**Heritage Council**

PCU025378

**TEMPE HOUSE SURROUNDS, ARNCLIFFE – SITE KNOWN AS DISCOVERY POINT  
– 1 PRINCES HIGHWAY, WOLLI CREEK – ENVIRONMENTAL ASSESSMENT FOR  
STAGE 1 – PROPOSED MIXED USE RESIDENTIAL DEVELOPMENT – MP 10\_0030**

Figure 4: Estimated disturbance zones based on the geotechnical report (Coffey 2003) and previous archaeological excavations. The Stage I development area is outlined in red. NB the orientation of this figure is different to Figure 2).

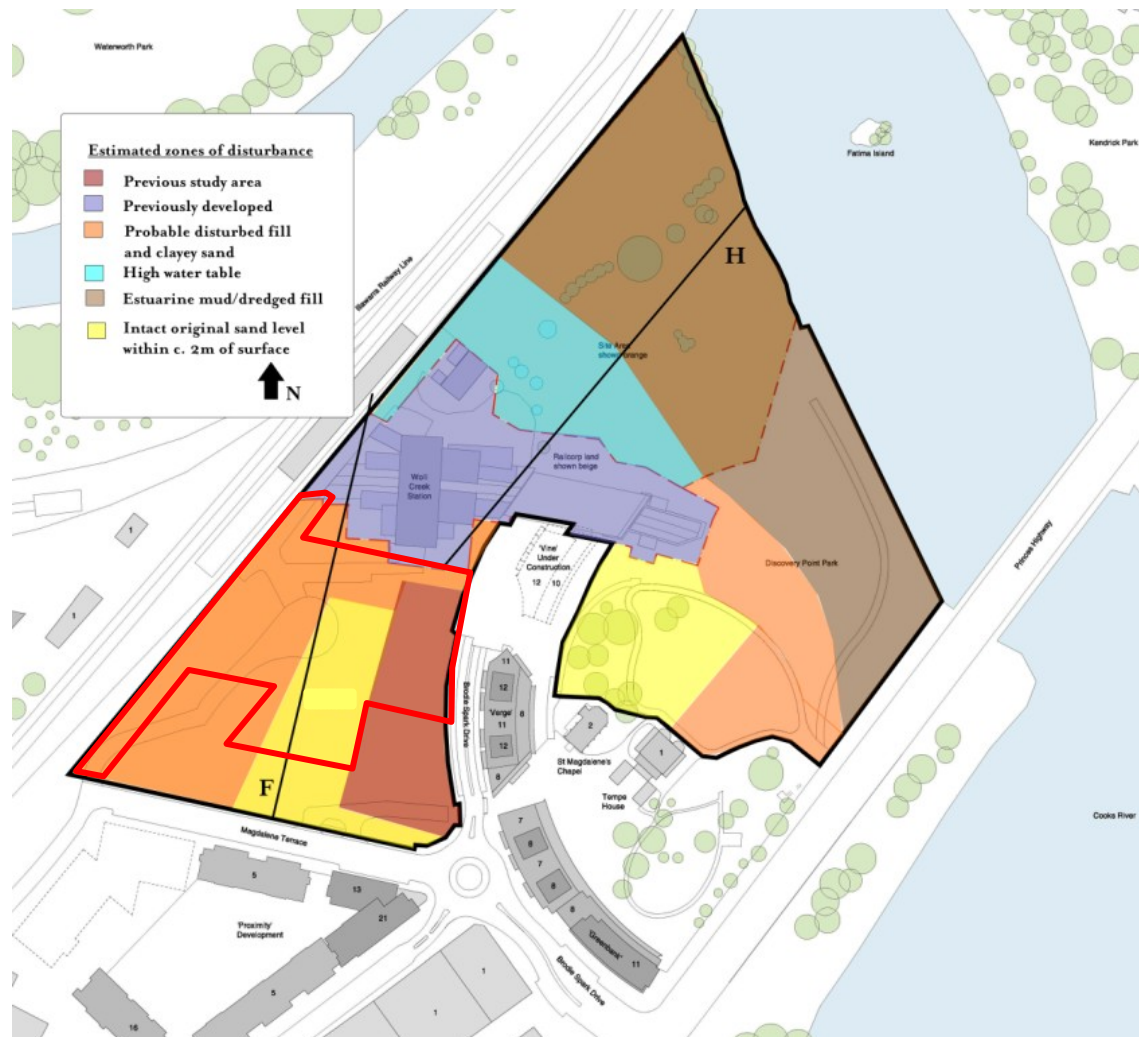
I note that this 2011 investigation of the potential relics and resulting assessment has not been updated for the current stage of development since the Concept Plan proposal assessment of June 2010. In particular, I note that the low likelihood of relics has not been verified by archaeological testing before submitting this development application to support the report's conclusions about the significance and appropriate management of these potentially state significant relics.

The Archaeological Management Plan (endorsed by the Heritage Council of NSW) recommends more detail in the excavation methodology than quoted in the proposed Statement of Commitments.

*Further archaeological investigation is required in the Zone 2 area of the Stage 1 development area. This part of the Precinct has not been investigated previously. Prior to commencement of construction works in this area a test excavation programme should be carried out by a suitably qualified archaeologist to ascertain whether intact archaeological material is present here.*

3. Before construction works commence, all affected historical archaeological 'relics' and/or deposits of local and state significance are to be subject to professional archaeological excavation and recording in accordance with the methodology specified in the Heritage Council endorsed Archaeological Management Plan prepared by Casey & Lowe Associates dated January 2002.
